From:
Sent: 25 October 2023 16:33
To: DCAdmin
Subject: Objection to amendment to 2023/91212 land off Bankfield Drive, Holmbridge.
Erection of 21 dwellings with access from Laithe Avenue.

Re planning application 2023/91212 erection of 21 dwellings on land off Bankfield Drive, Holmbridge

Date:	21.01.21	Project:	Bankfield Drive, Holmebridge
Scale @ A3:	1:500	Drawing Number:	2021.01.003
Drawn By:	CD	Revision:	V

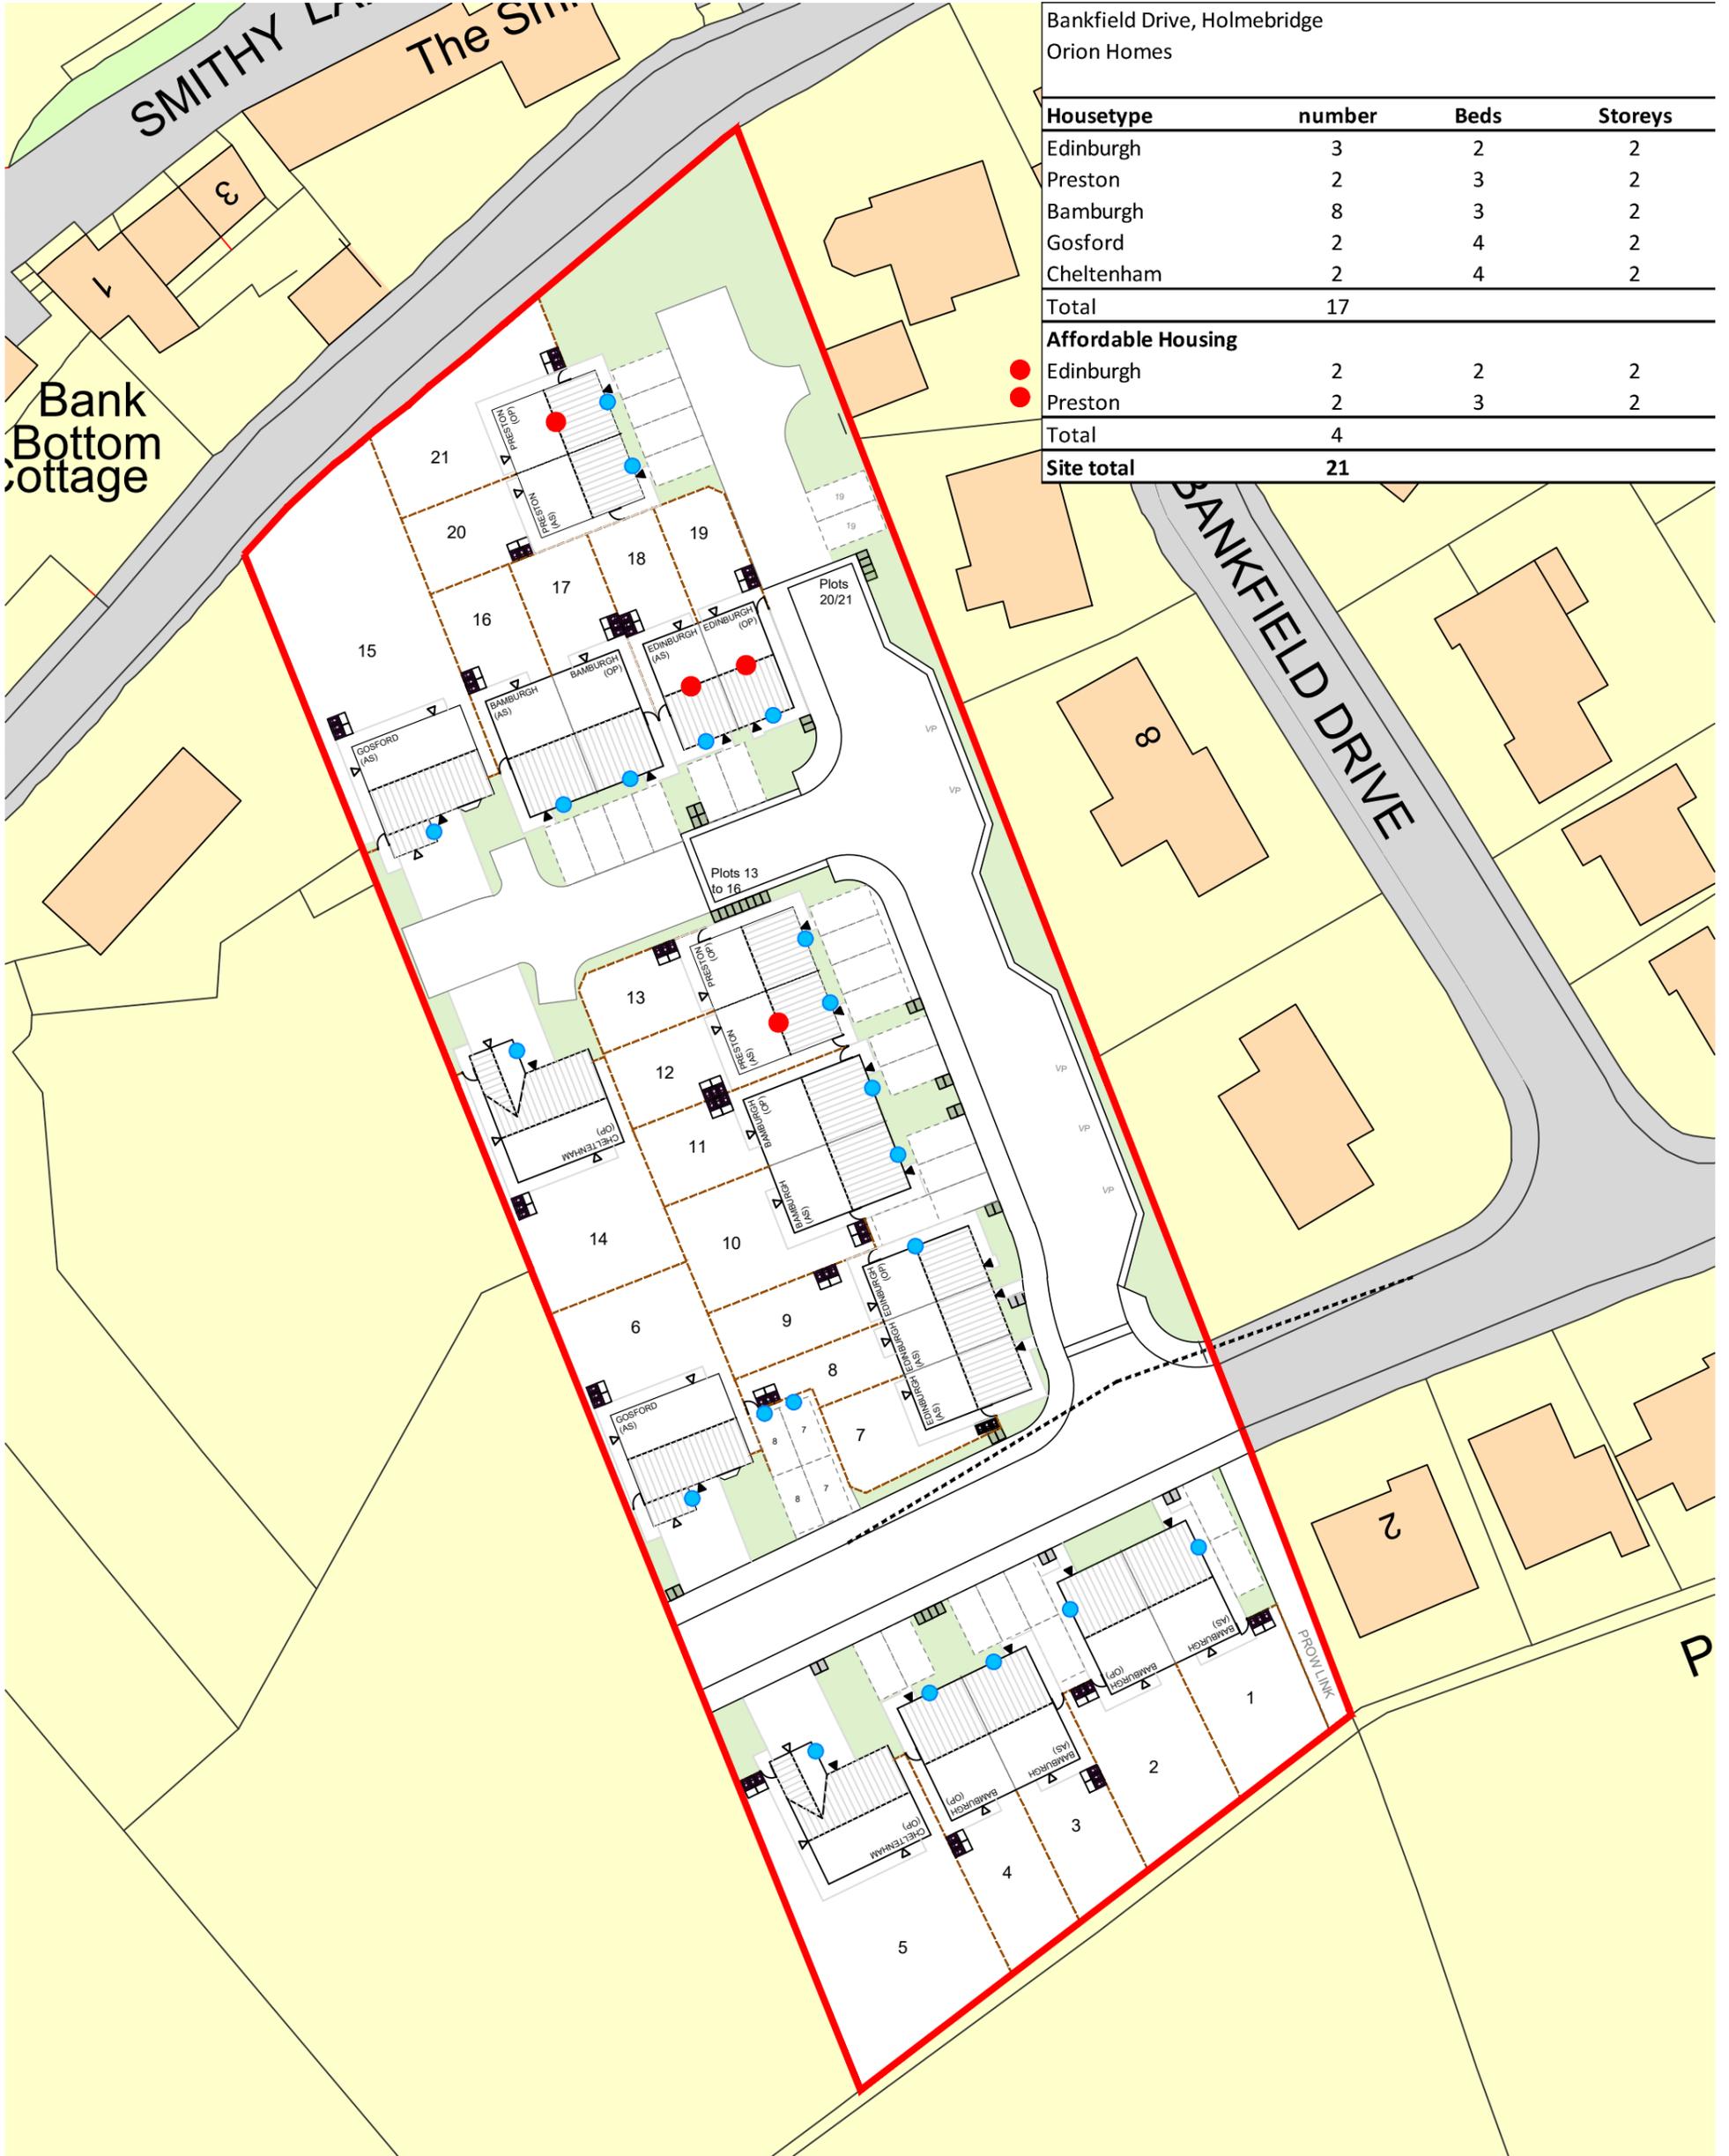
- 21 houses are an over intensification of the site and the density and character of the properties proposed are completely out of line with the existing estate which only has 12 detached houses on a similar sized plot. The new design includes a terrace of 3 properties and several semi-detached. Construction should be of natural stone to match surrounding properties.

- The 65 Comments received in the May comments from local residents , 95% of which expressed concern over road safety and high density of the site, have been largely ignored.
 - On a positive note the new road layout is an improvement on the original plans.
-
